Charlotte Department of Transportation Memorandum

Subject: Rezoning Petition 07-045: Located on the west side of Euclid Avenue
between McDonald Avenue and East Tremont
Avenue (revised 5/12/07)

ILLUSTRATIVE SITE PLAN

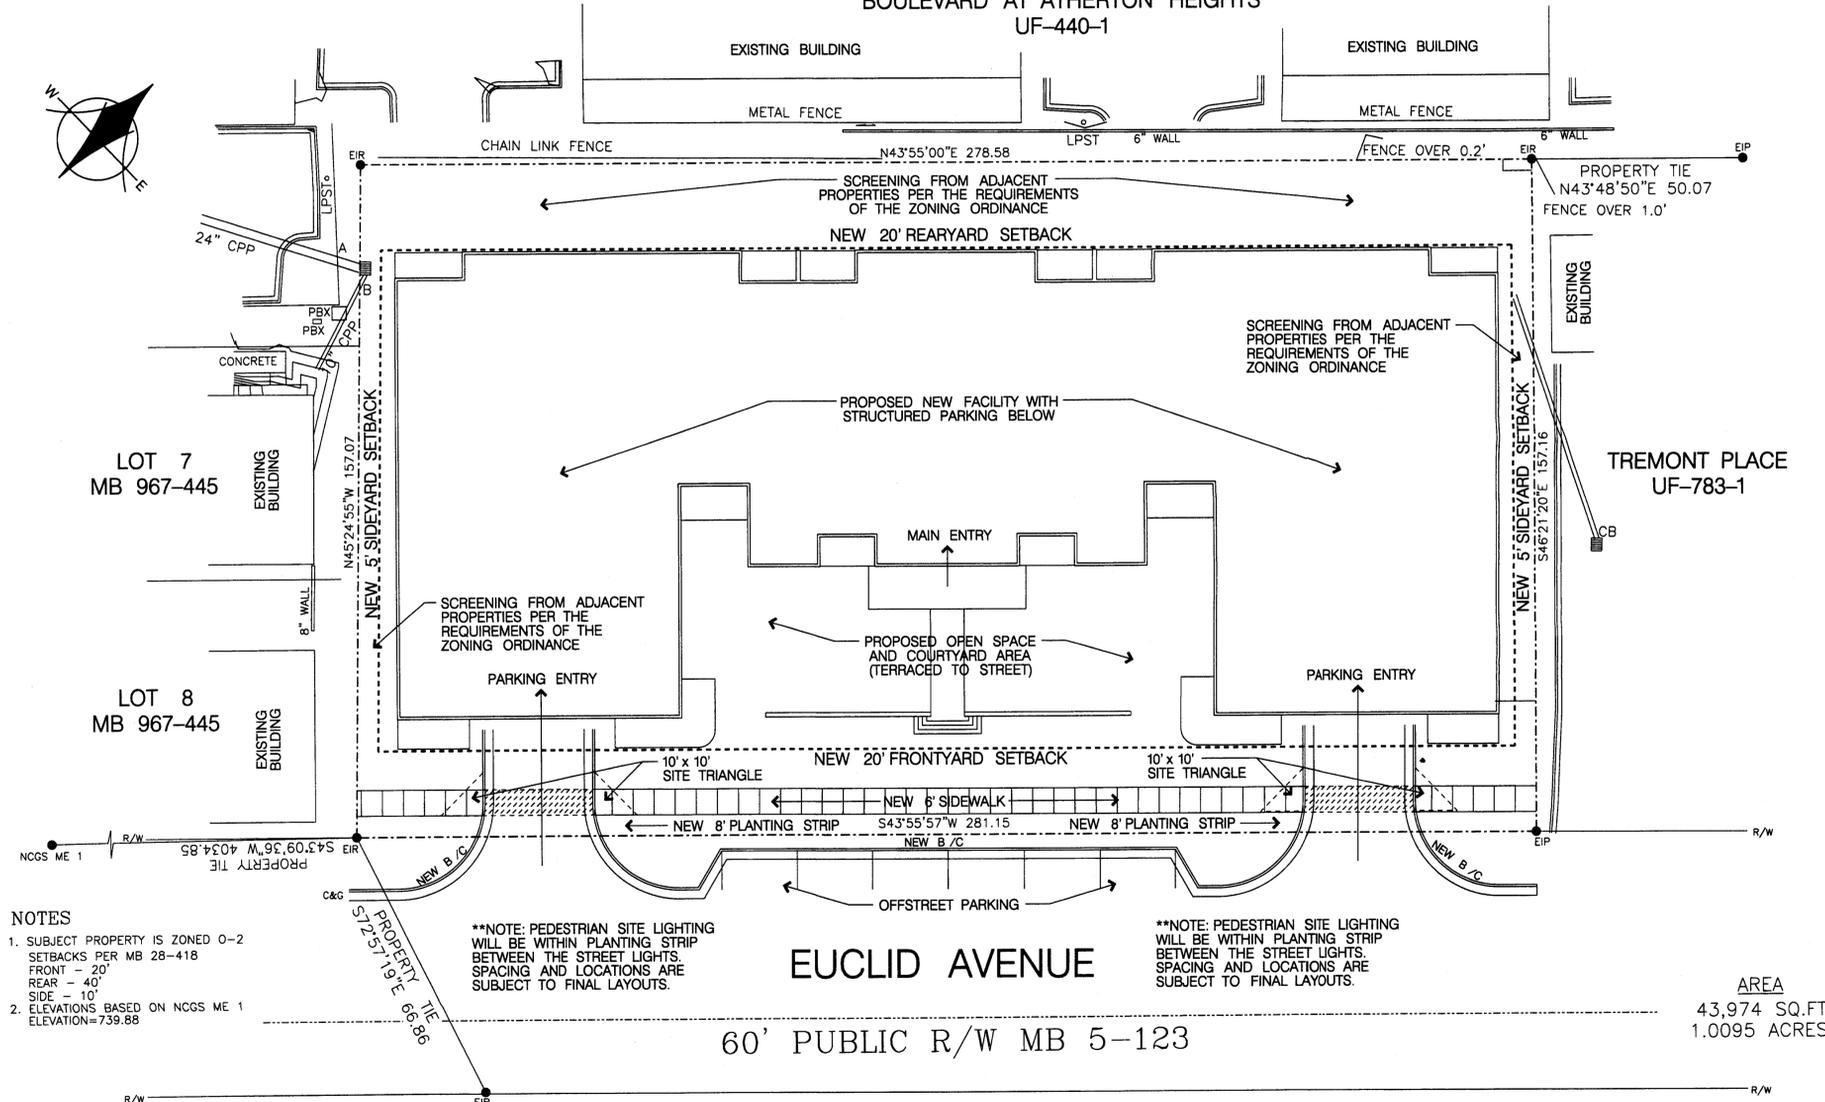
The several remaining site plan issues related to the driveway design and curb/parallel parking alignment on Euclid Avenue will be addressed during the TOD review process.
